FW: CM/27/20/DOC - Langford, Horsemere Green Lane, Climping, BN17 5QZ

From: Kate Giddings <kate.giddings@arun.gov.uk>**Sent:** 09 September 2020 17:08**To:** Anita Gardner <Anita.Gardner@arun.gov.uk>**Cc:** Joanne Lewis <Joanne.Lewis@arun.gov.uk>**Subject:** CM/27/20/DOC - Langford, Horsemere Green Lane, Climping, BN17 5QZ

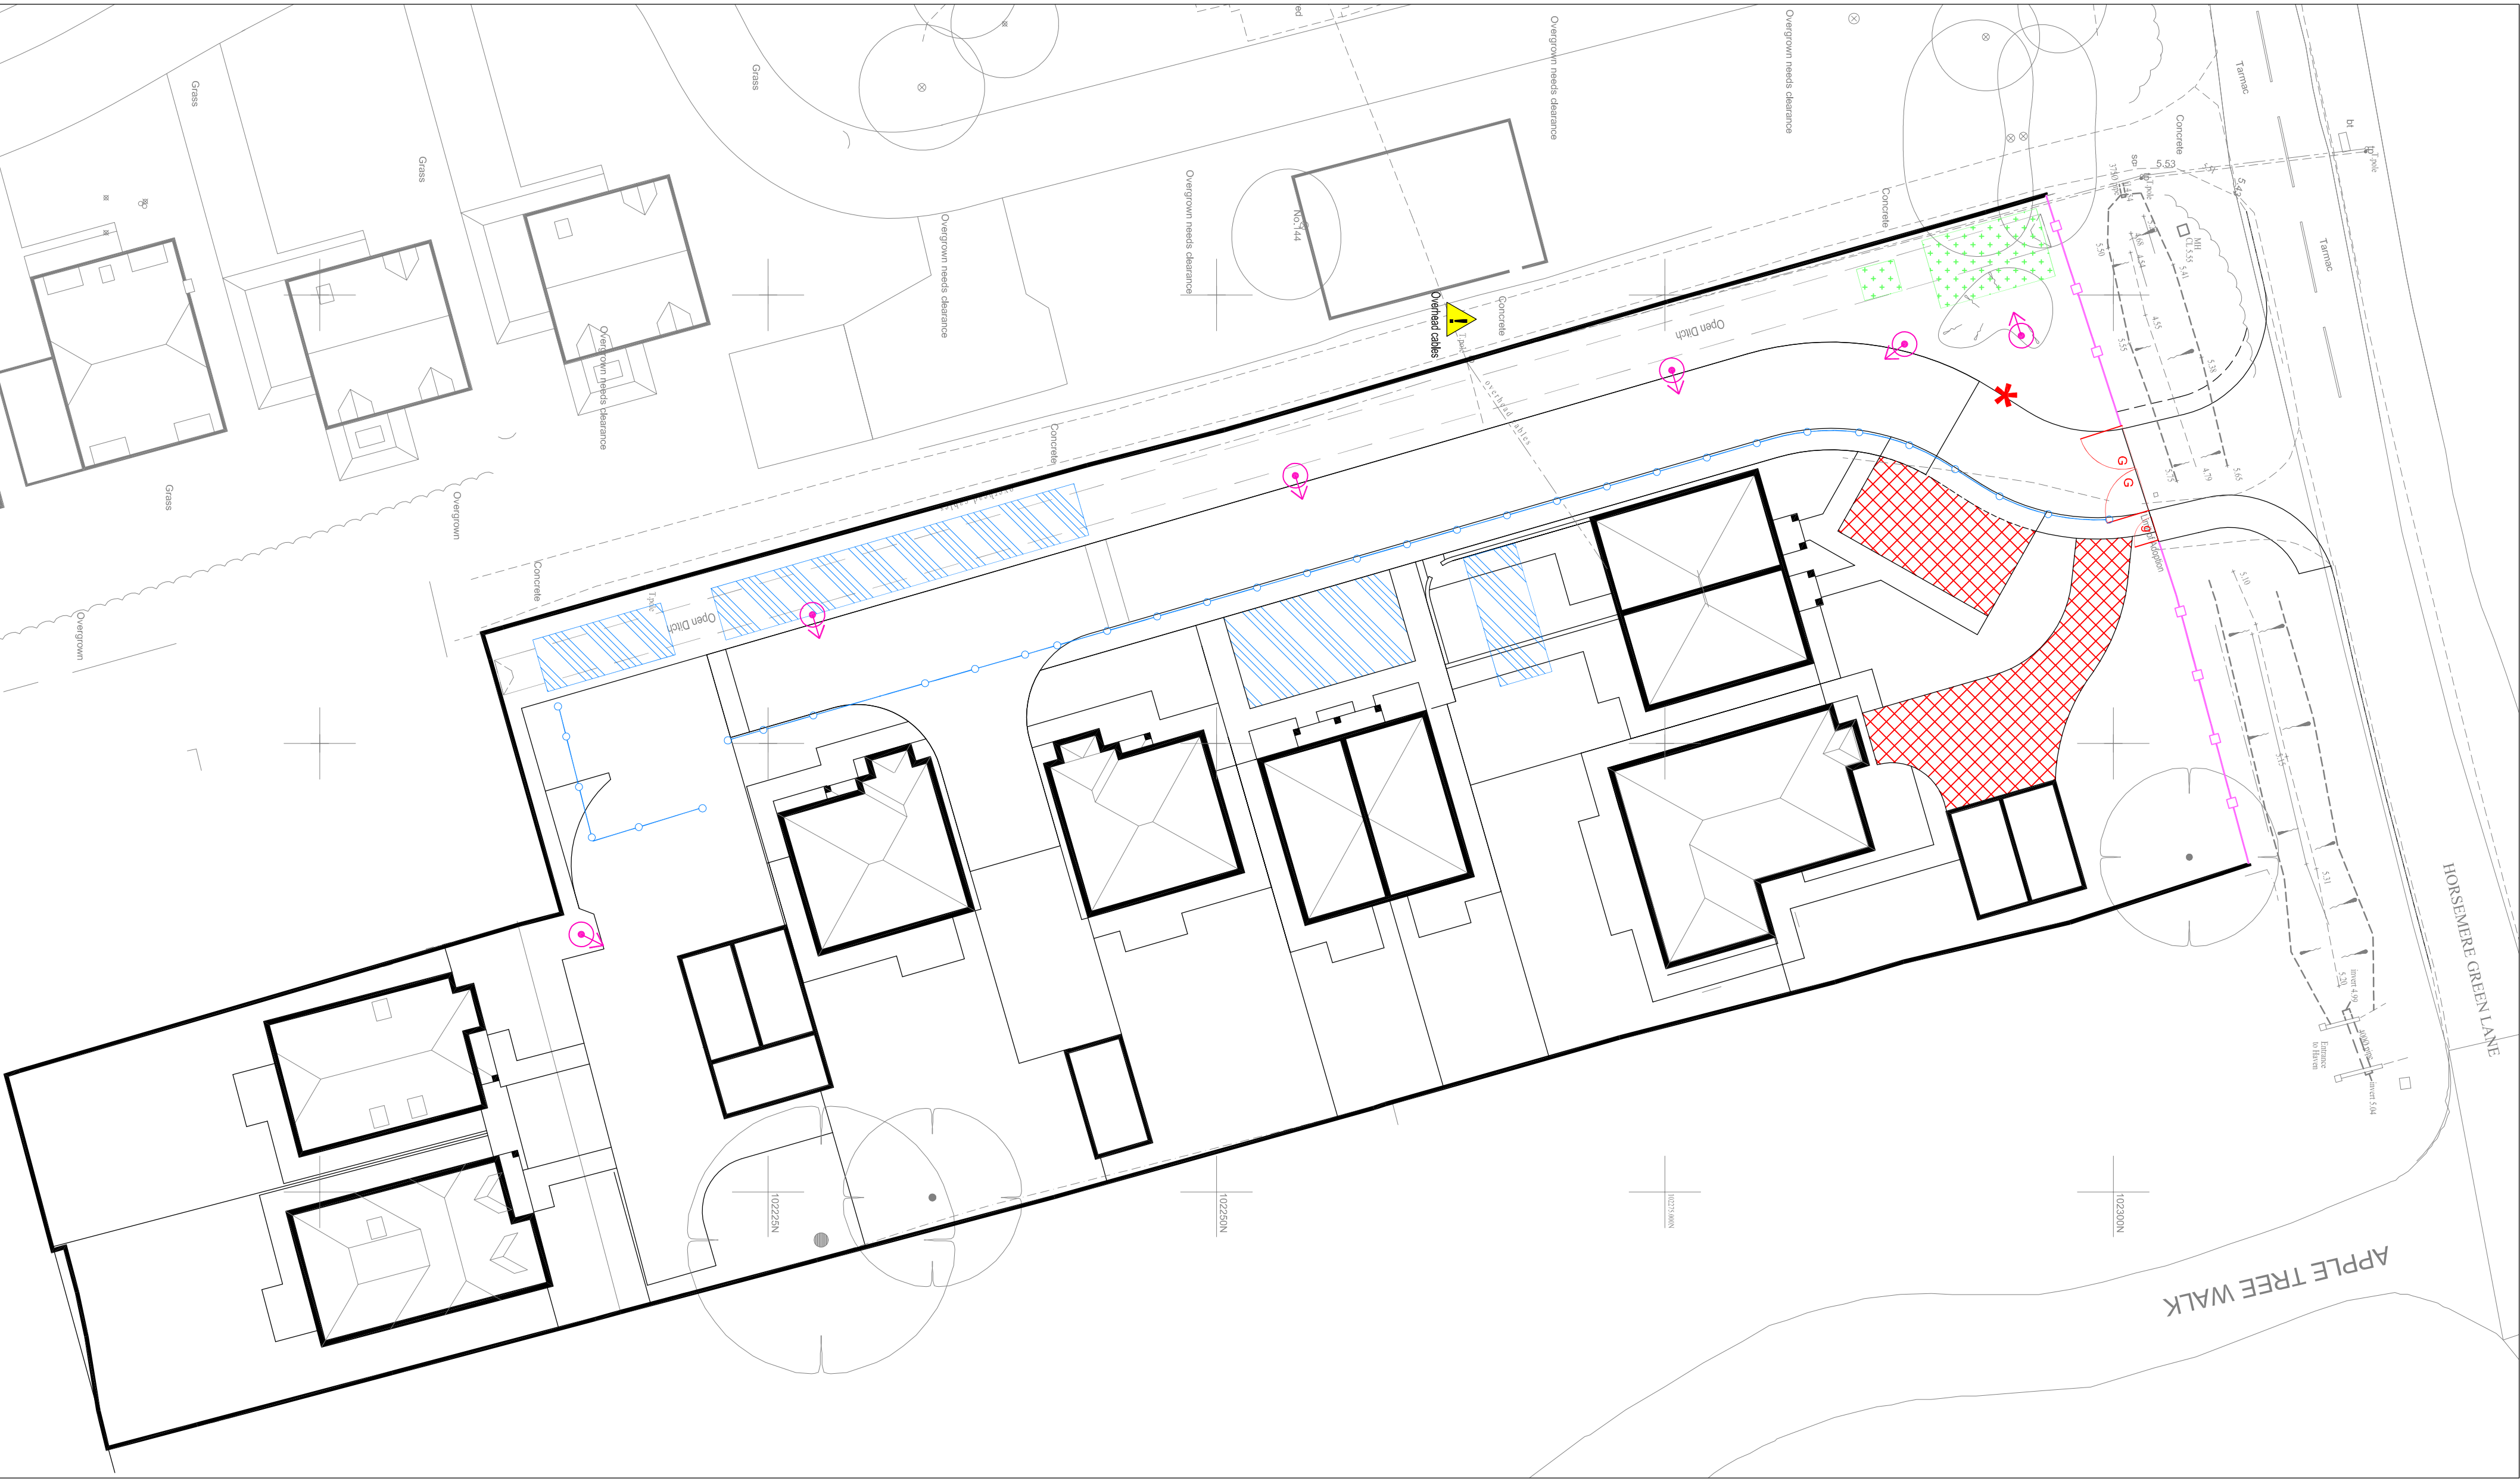
- details of the arrangements for public engagement/consultation, prior to and during demolition/construction work
- further detail is required regarding the control of mud, dust and wash-off from the proposed wheel-washing facility

- further detail is required regarding the measures to minimise the noise, including vibration, generated by the construction process
- further detail is required regarding the measures to control the emission of dust and dirt during construction

A more clear copy of the proposed site set-up would please be appreciated.
